# Memorandum

**Date:** January 19, 2024

**Re:** DFT Final Sign-Off NDBP Aquatic Center PR 2023-008180

## **CONDITIONS OF APPROVAL – SI 2024–00062 – DFT Final Sign-Off**

AS-101
COPYRIGHT 2023 HUITT-ZOLLARS INC.

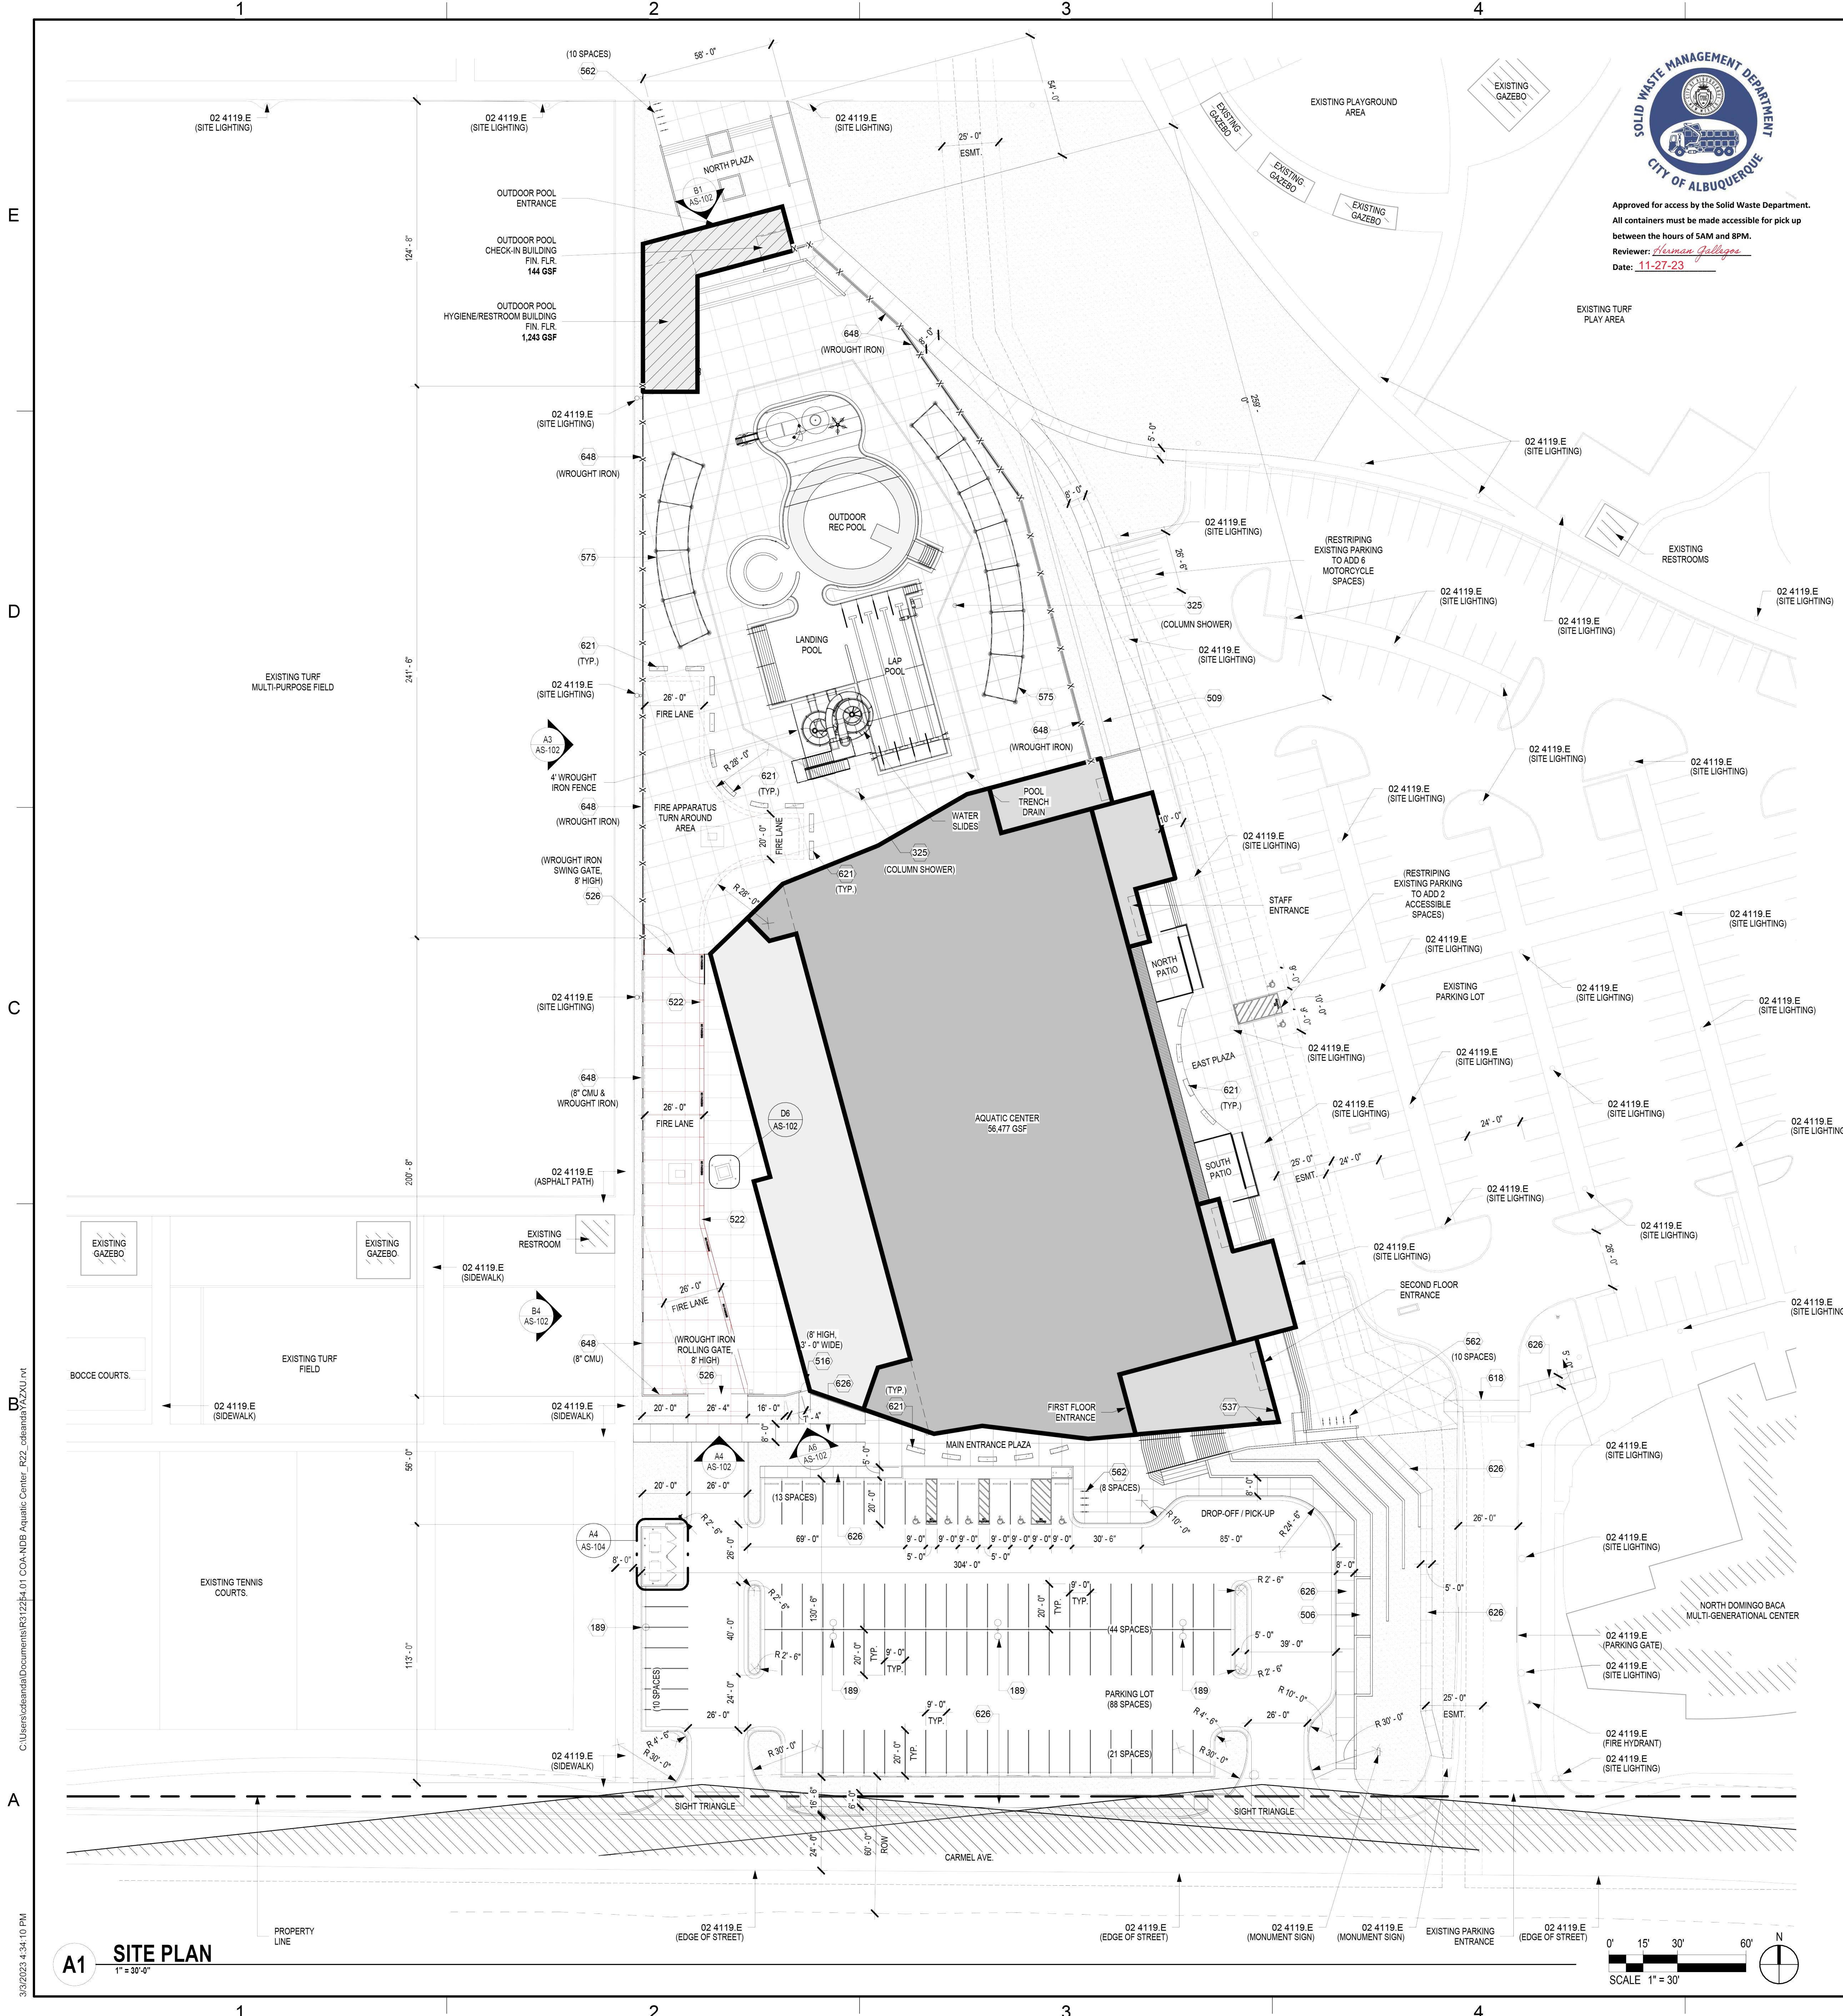
1. The project and application numbers must be added to the Site Plan top sheet.

*Applicant Response: The project and application numbers have been added to the Site Plan top sheet.*

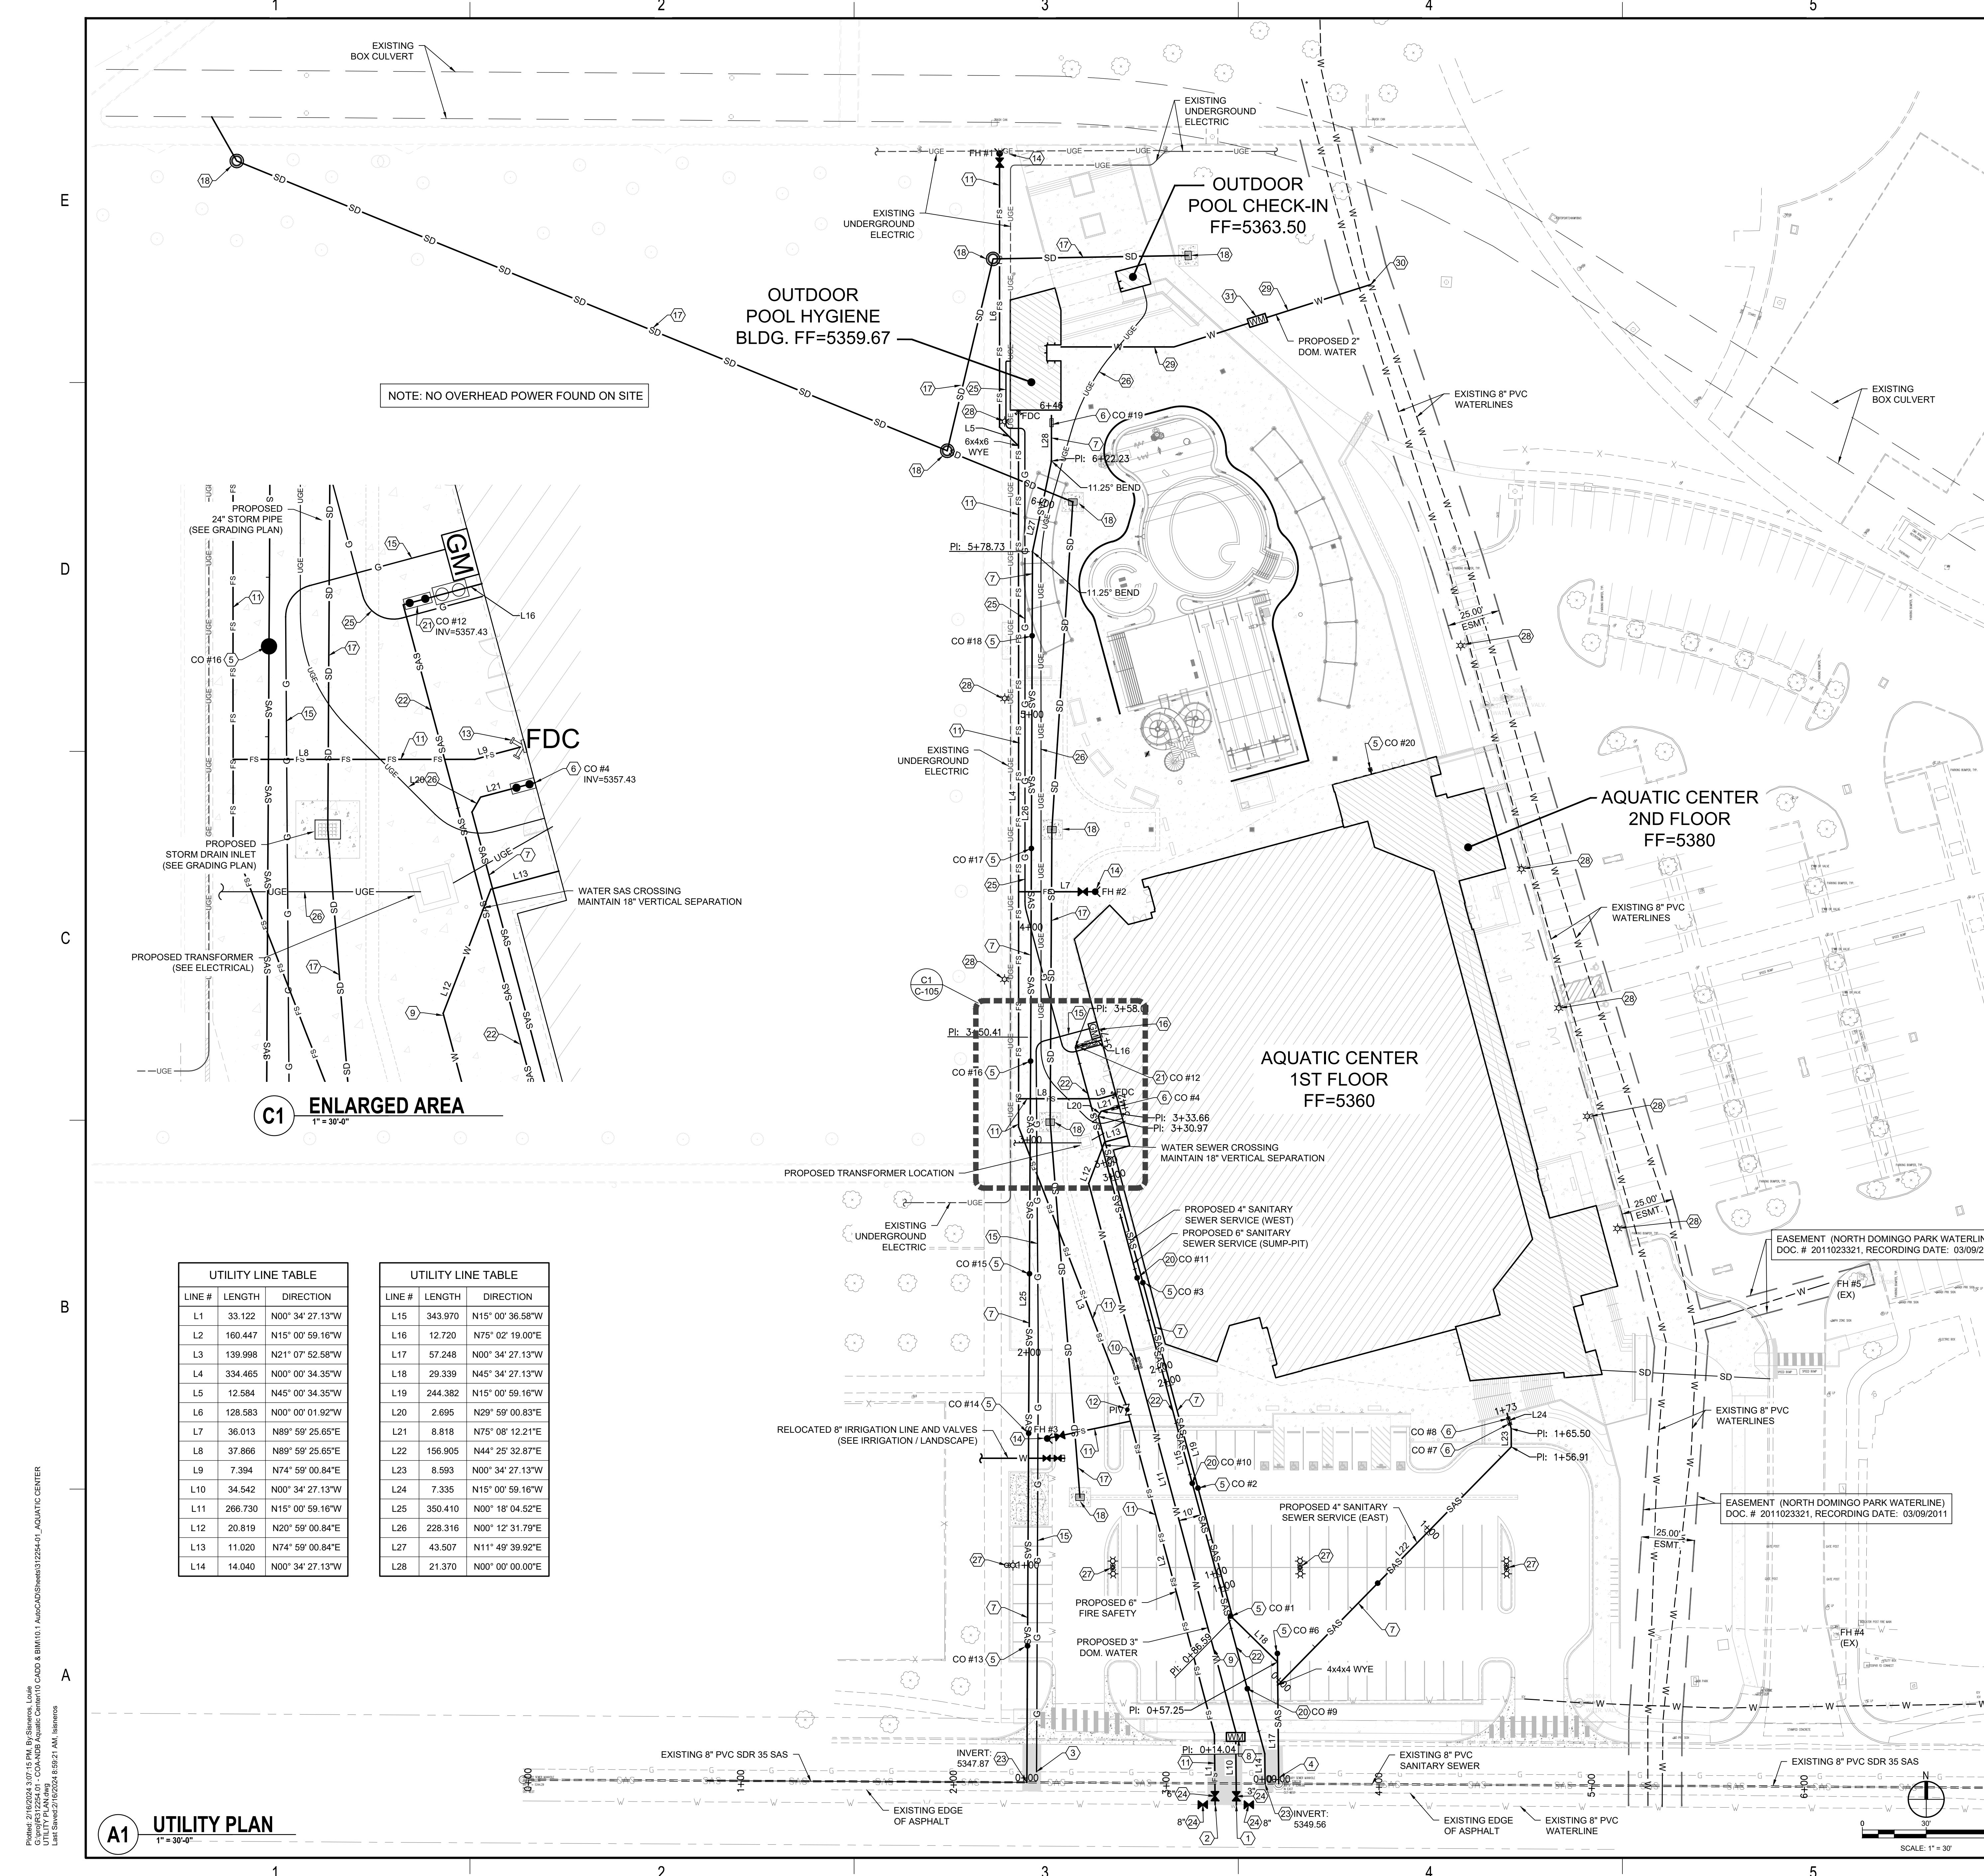
3. The landscaping plan must be revised to show the plant palette and other above ground improvements in the waterline easement running diagonally through the aquatic center area are acceptable to the ABCWUA.

*Applicant Response: The landscape plan has been revised to show the plant palette and other above ground improvements in the waterline easement as required and are acceptable to the ABCWUA.*
